SCOPING OPINION:

Proposed Ray II Wind Farm

Case Reference: EN0110031

16 June 2026

Figure 6.5
 Turbine Blade Tip Height Zone of Theoretical Visibility to 45 km

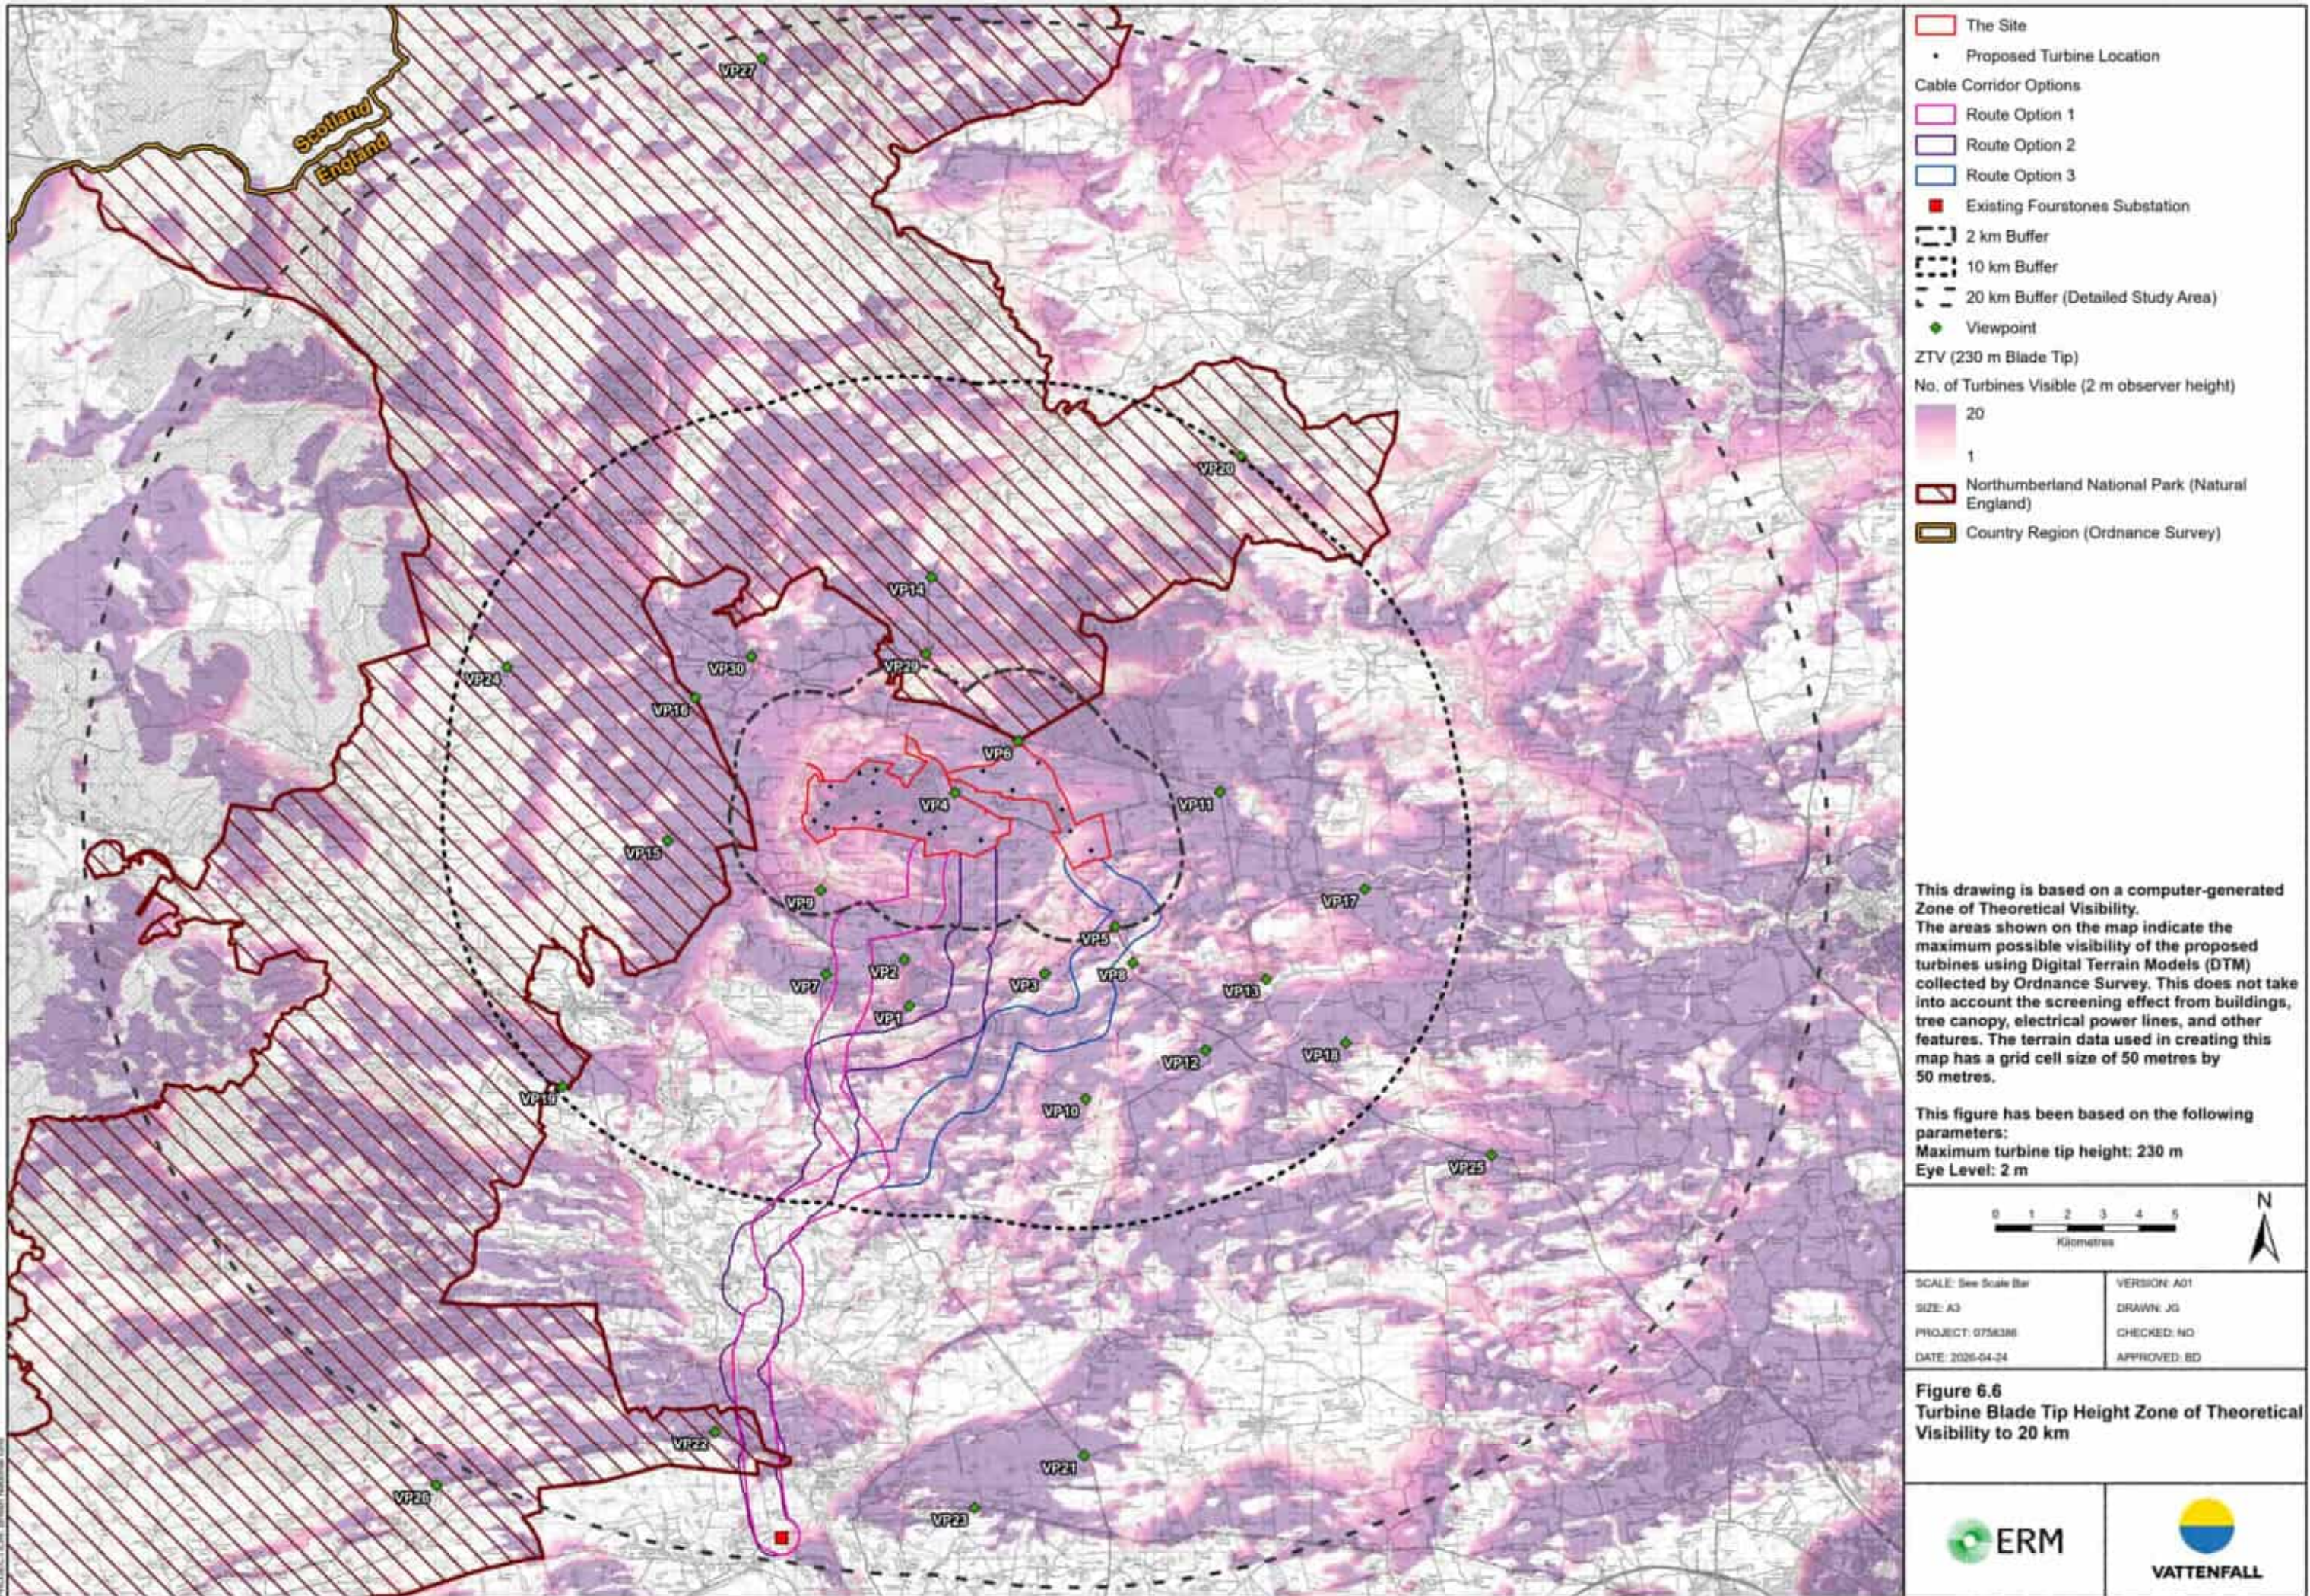
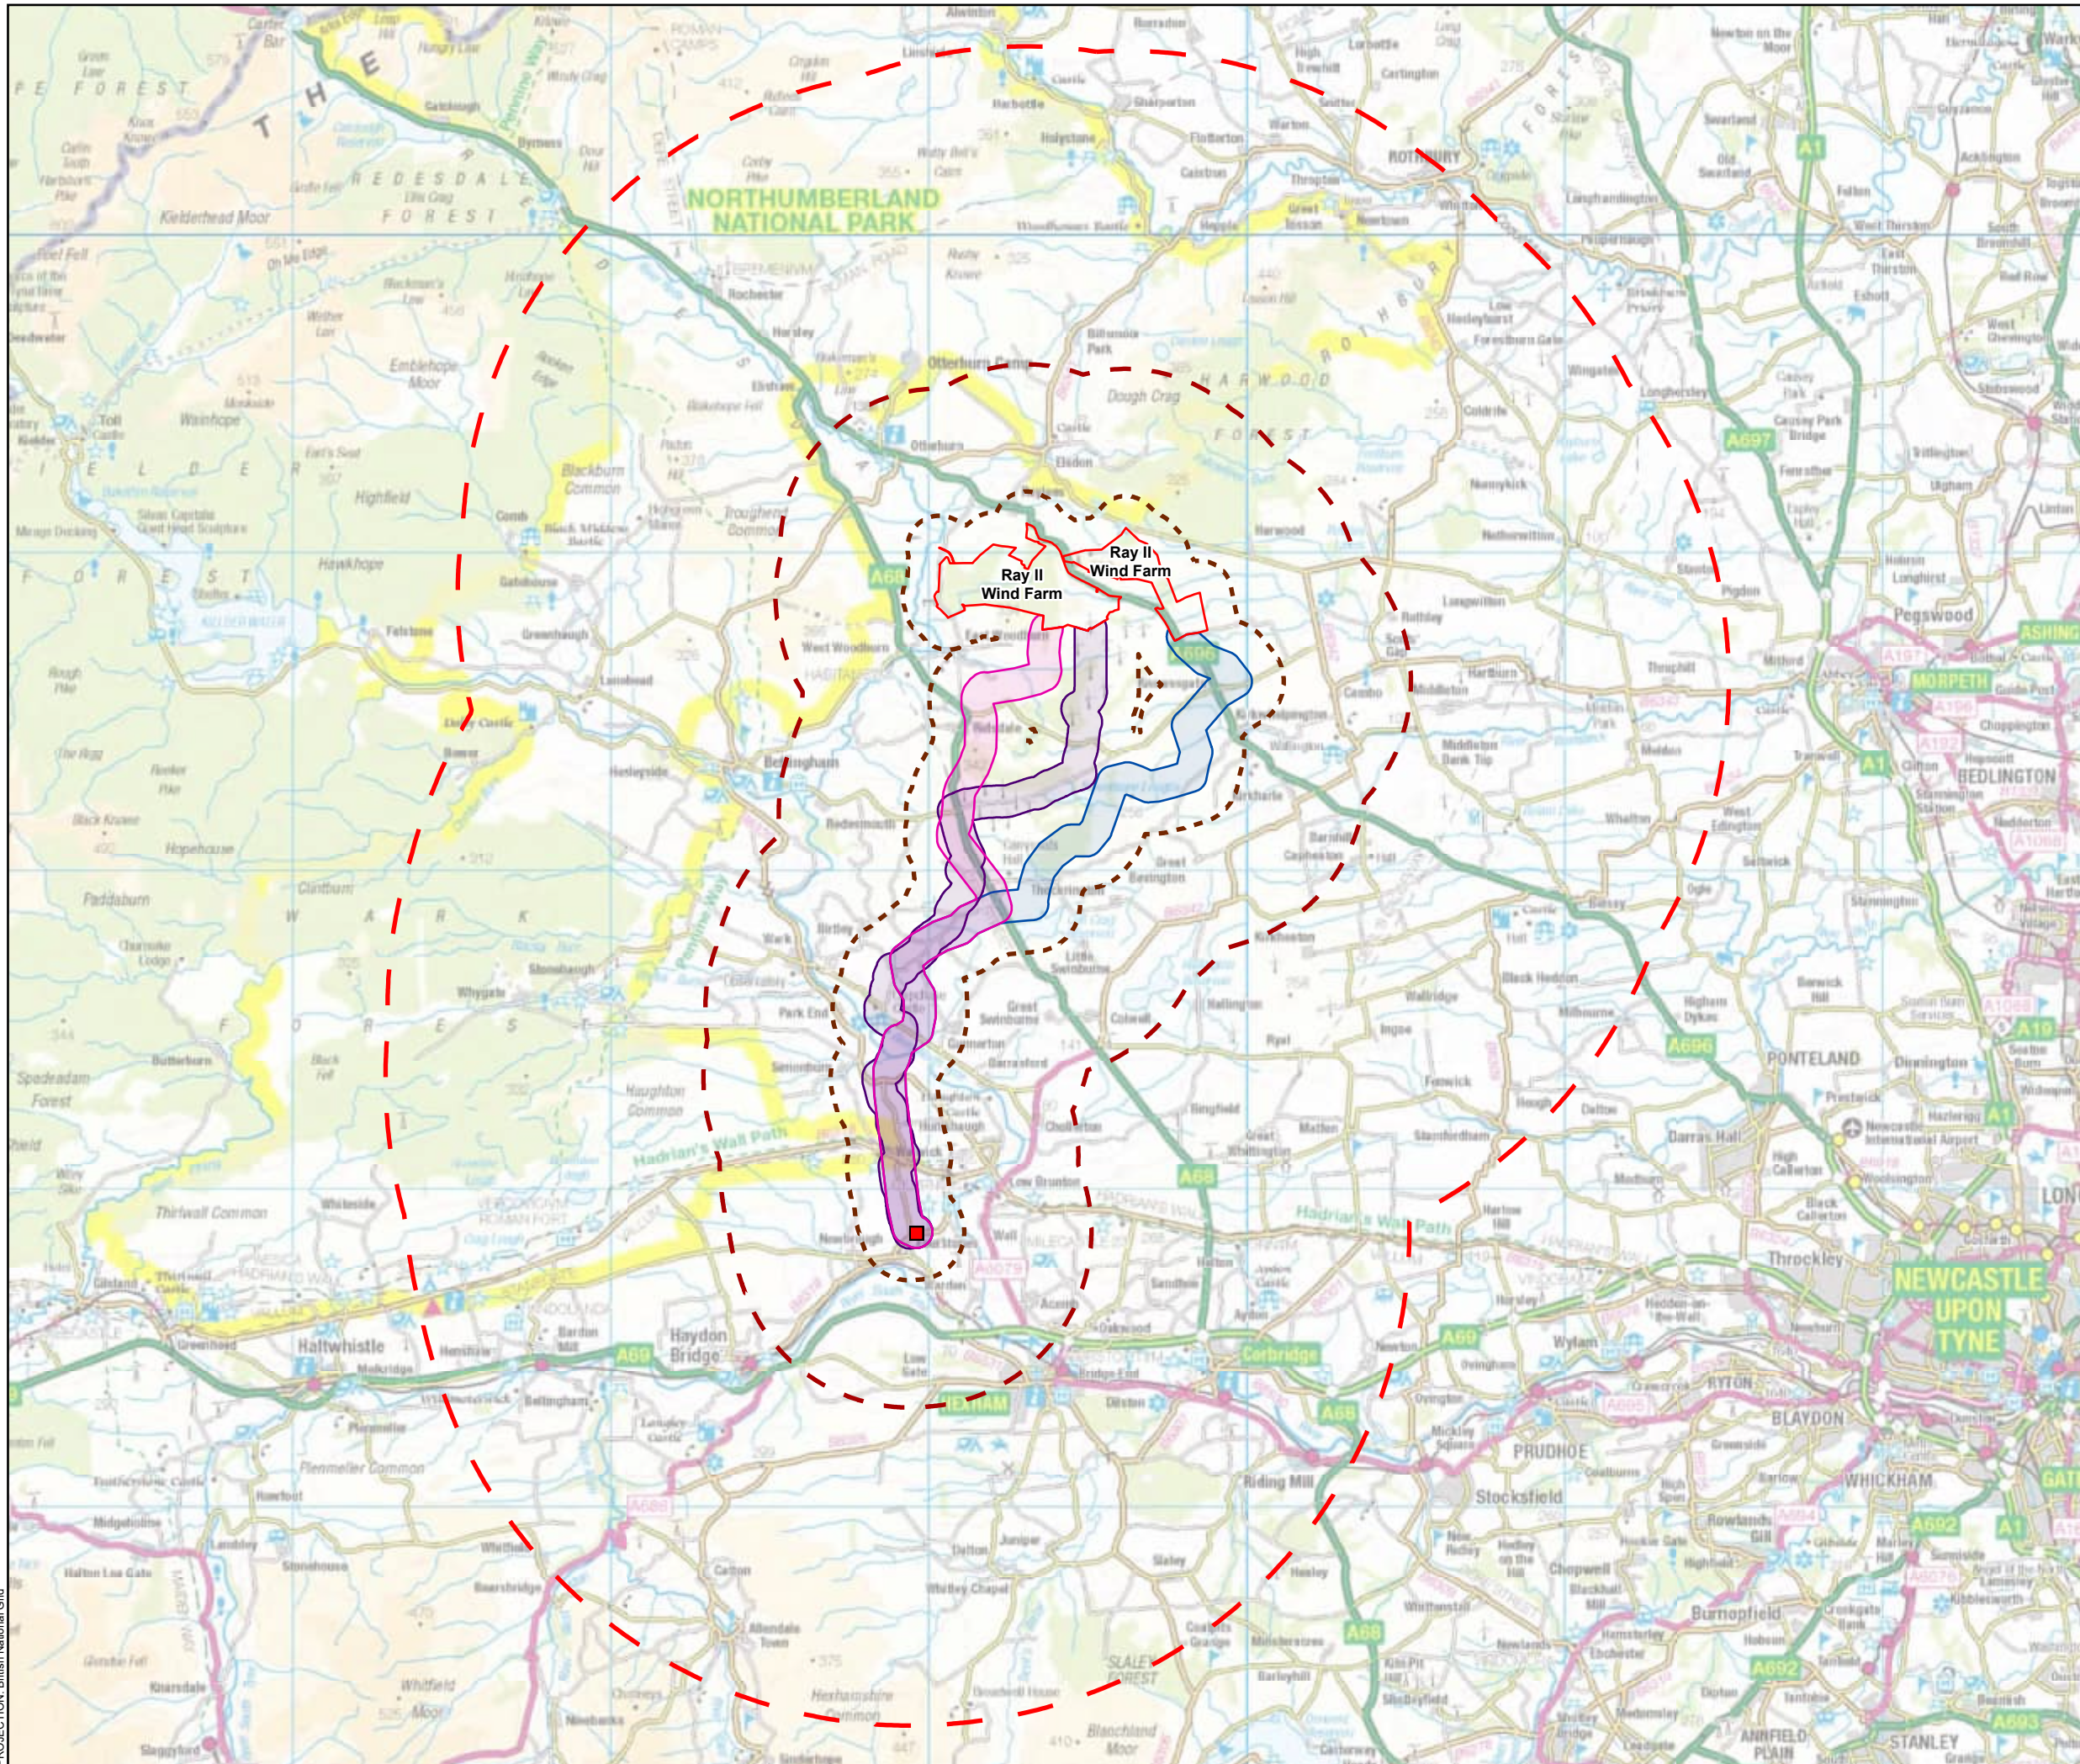
3.1.8	Figures 6.5 and 6.6	ZTV	It is currently unclear whether the grid connection will be installed above or below ground. The use of overhead lines with associated pylons could give rise to landscape and visual effects. The Scoping Report does not provide any ZTV for the cable corridor options area. As such, a separate ZTV should be provided to assess the potential visibility and effects of cable infrastructure outside of the turbine area.
